Ann Machado <amachado@portlandmaine.gov>

Riverview

Thu, Oct 27, 2016 at 4:23 PM

Drawing Name:	Lot 2 Site, Utility, Grading and Drainage Plan
Project:	Riverview Street Lots Portland, Maine
Client:	Diversified Properties P.O. Box 10127, Portland, Maine 04104

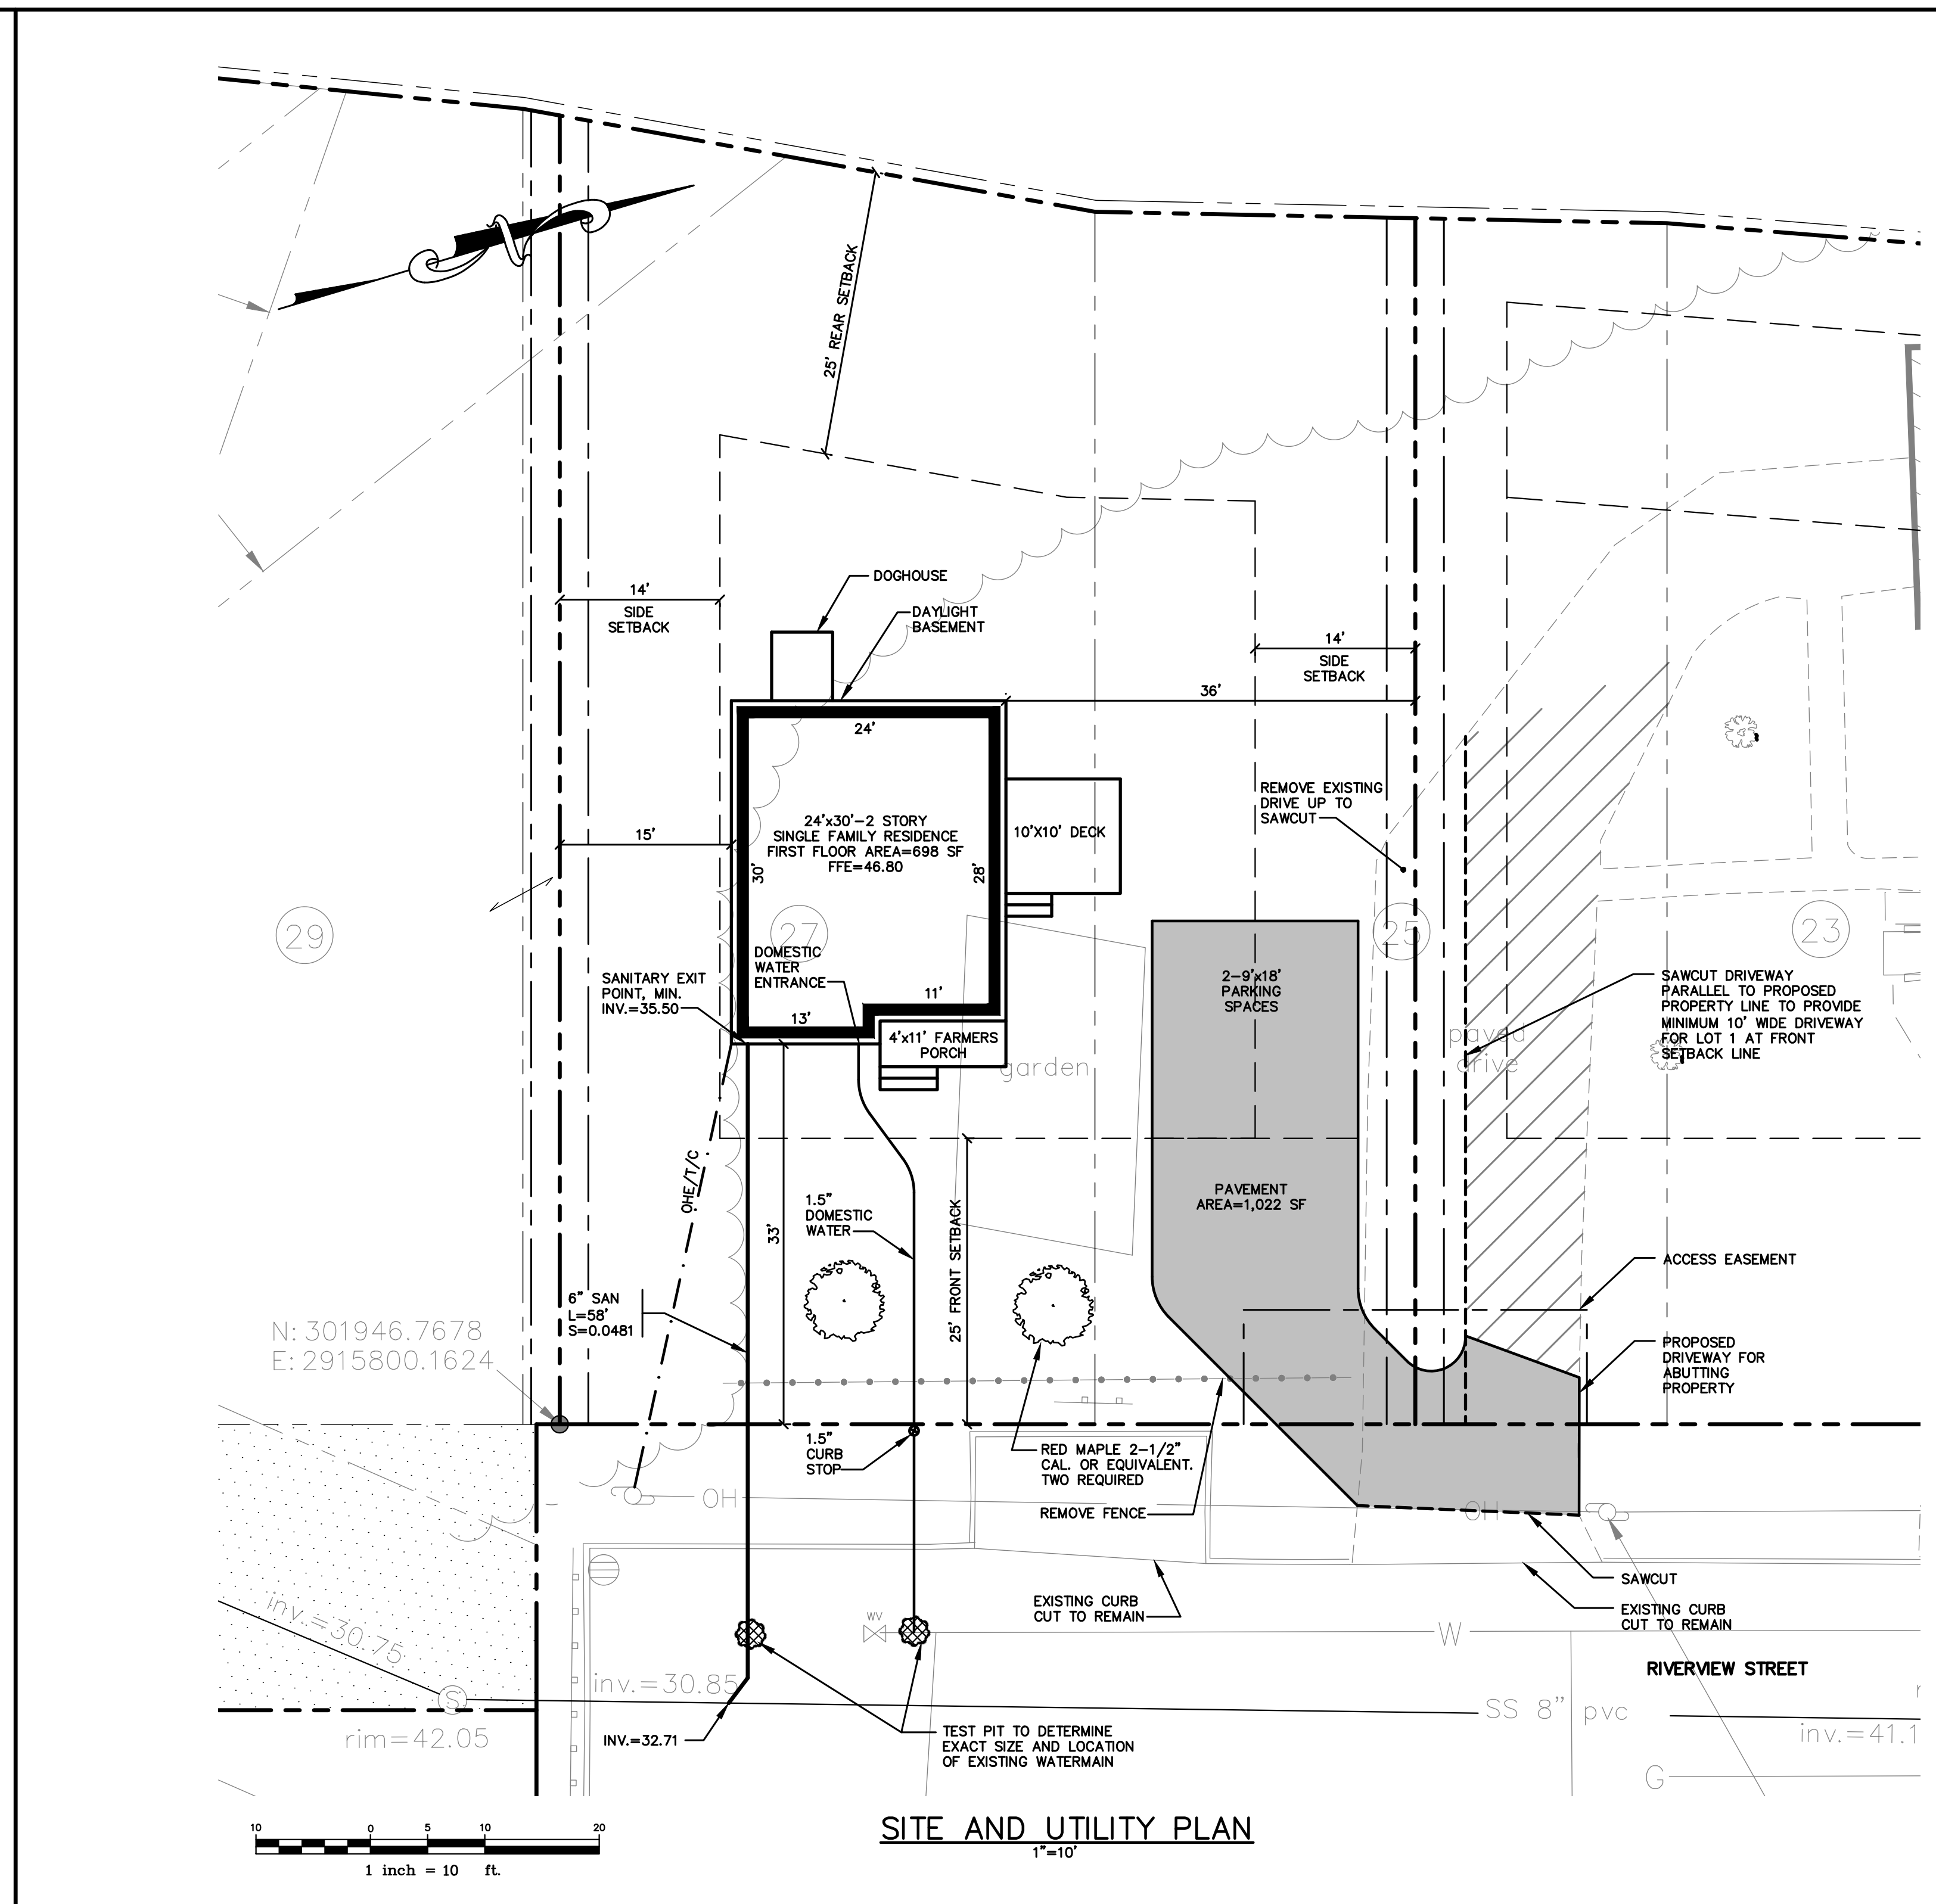
Thanks for the plan from Doug Reynolds. Besides just the rip rap area, there was more area that was disturbed beyond what was shown on the original site plan. I would like to have Doug locate the original line for disturbed area to show all the parts that were cleared beyond just the rip rap.

Once that is determined, you need to submit a replanting plan for all the area that was disturbed beyond the original line for disturbed area. The replanting plan should include the species that are being planted and the number of plants.
